Re: Land to the East of Shripney Road, Shripney, Bognor Regis

We have today submitted via the Planning Portal a Non-Material Amendment (NMA) to planning permission BE/73/25/S73 under reference **PP-14602550**.

The proposed amendment relates to changing the specification of grass to the rear gardens of properties from **'Proposed lawn to back gardens – Naturescape N14 Flowering Lawn Mixture or similar' (as approved)** to **'Proposed amenity lawn to back gardens using high quality turf - Rowlan Medallion or similar' (as proposed)**.

Detailed Planting Plan 1 of 3

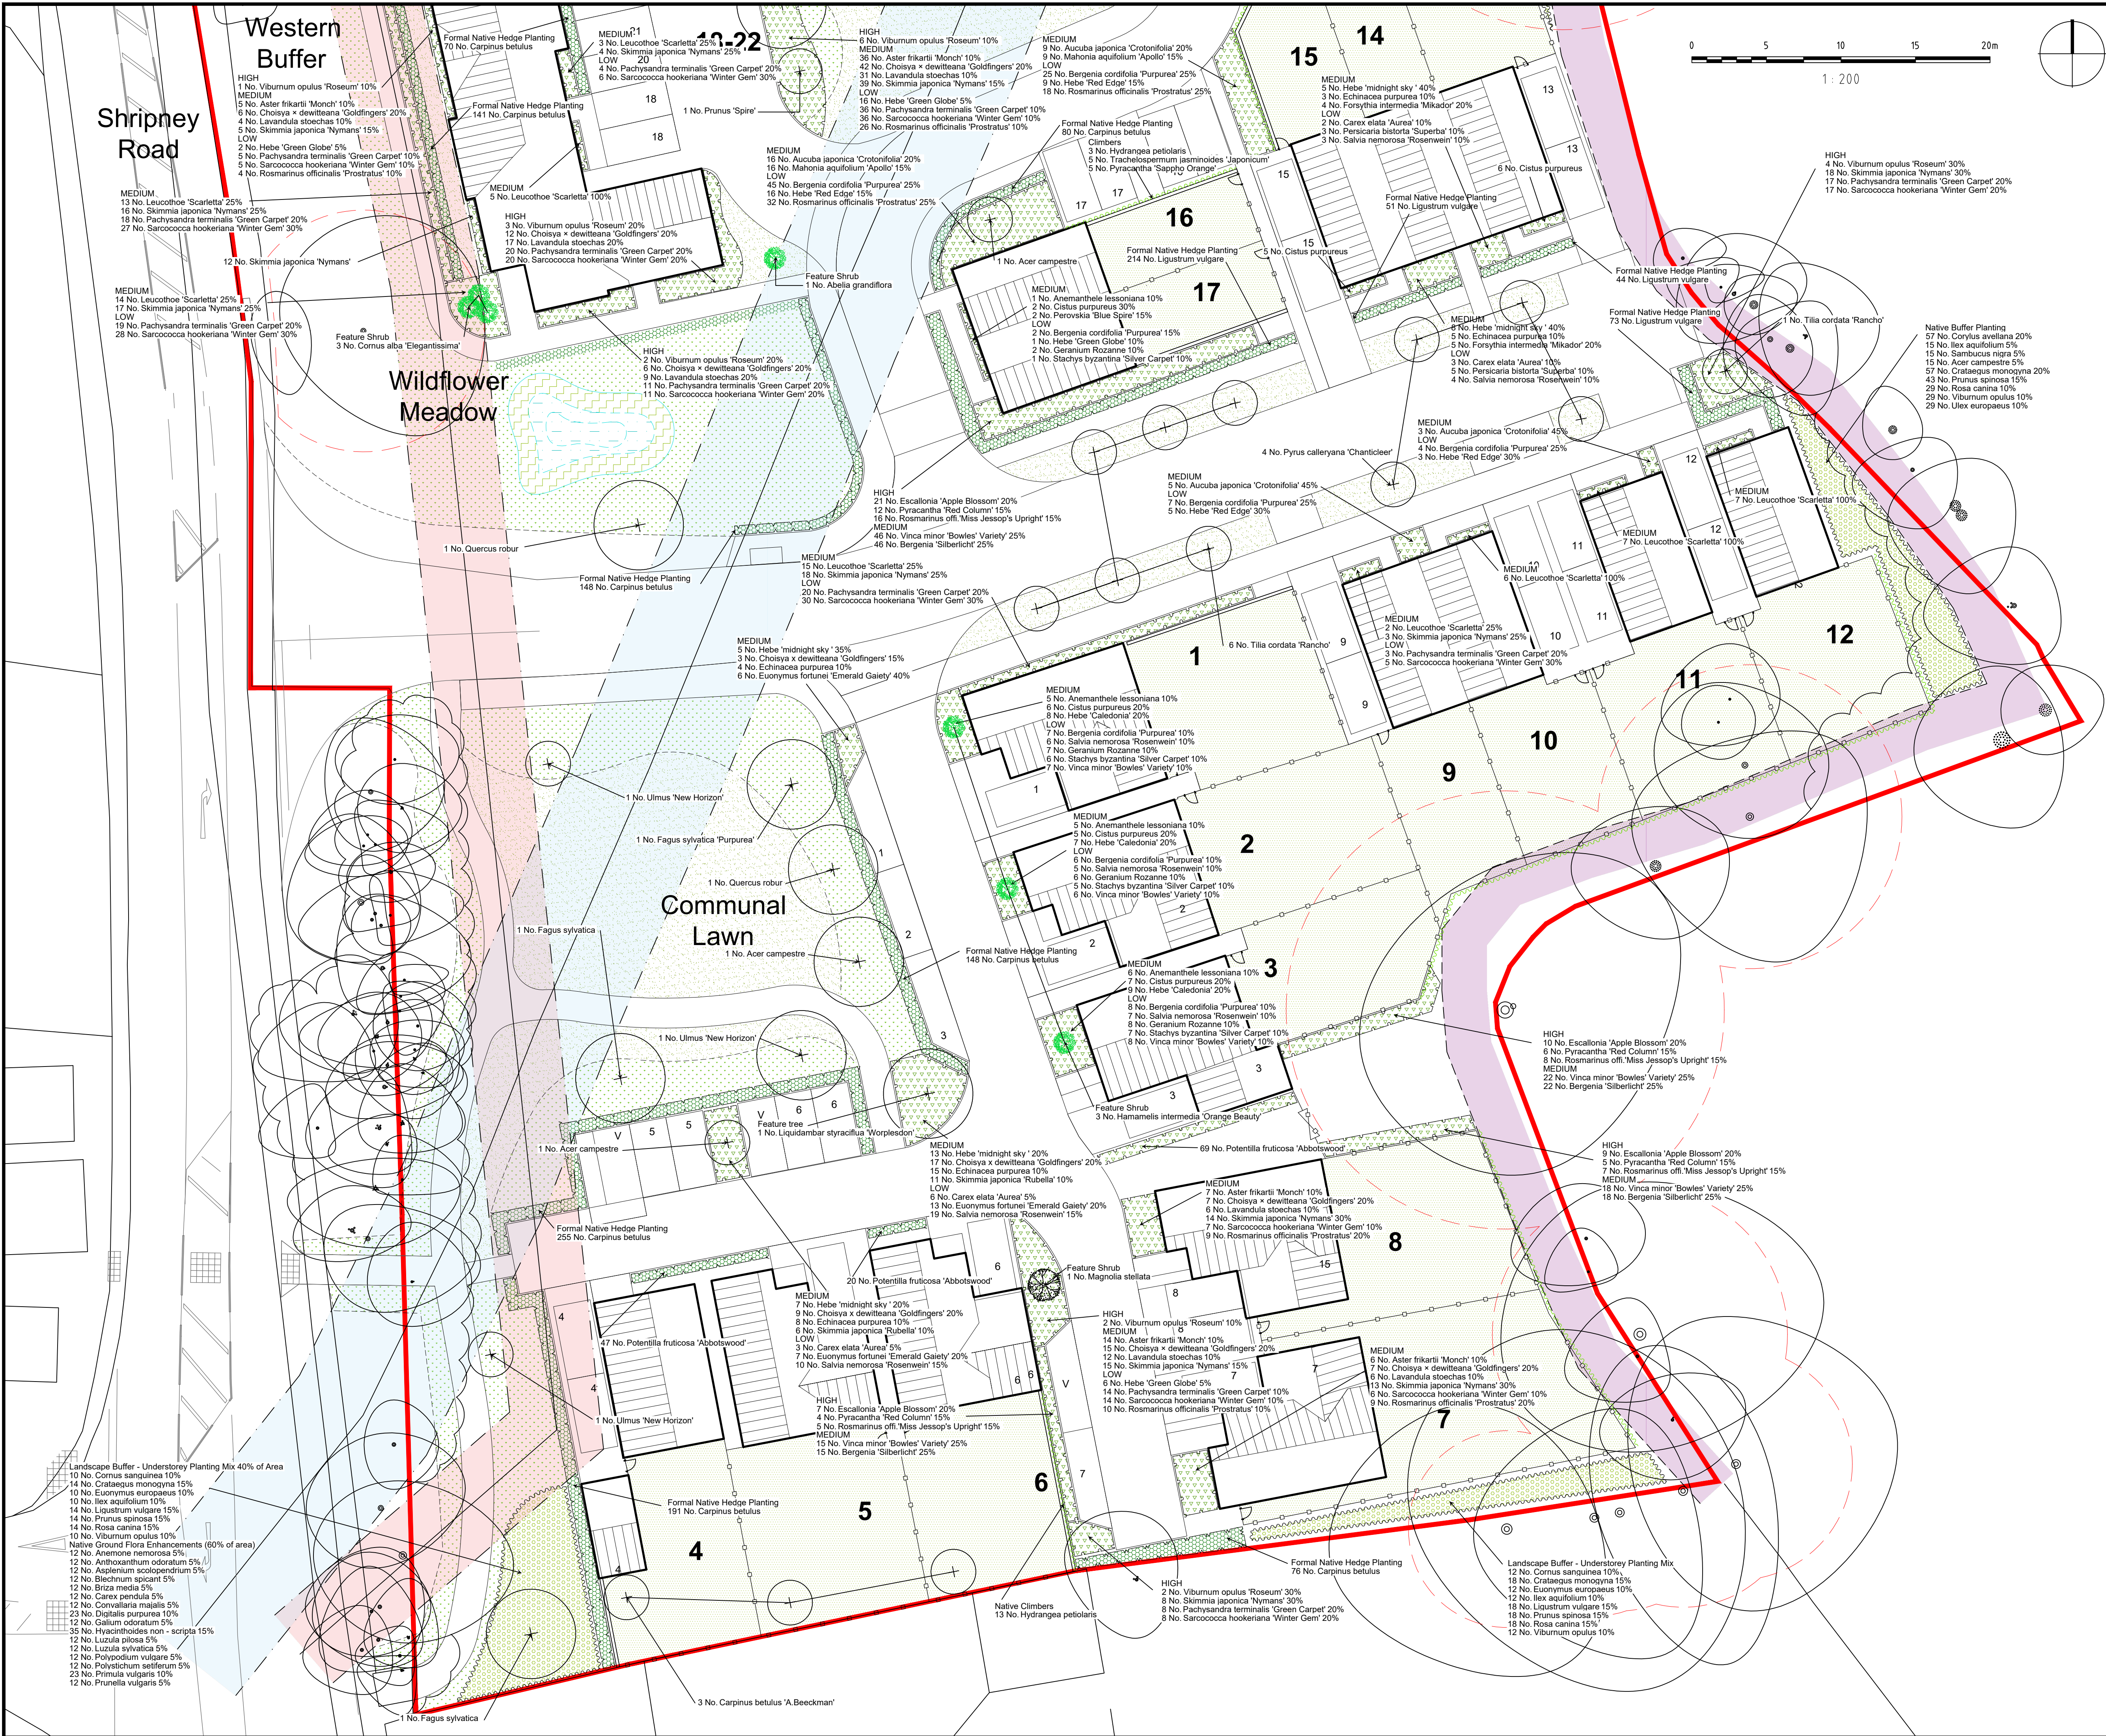
This proposed change is at the request of Aster Homes (Housing Association), with whom we are currently in contract for the sale of all 44 plots on the site. A flowering lawn mixture in rear gardens creates maintenance issues for the homeowners, and hence a more typical turfed amenity lawn is preferred.

- 602-01 Rev H Engineering Details Drainage Layout (UNCHANGED)
- DD598L01 Rev D Illustrative Landscape Strategy Plan (UNCHANGED)
- DD598L03 Rev C Detailed Planting Plan 1 of 3 (REVISED)
- DD598L04 Rev C Detailed Planting Plan 2 of 3 (REVISED)
- DD598L05 Detailed Planting Plan 3 of 3 (UNCHANGED)
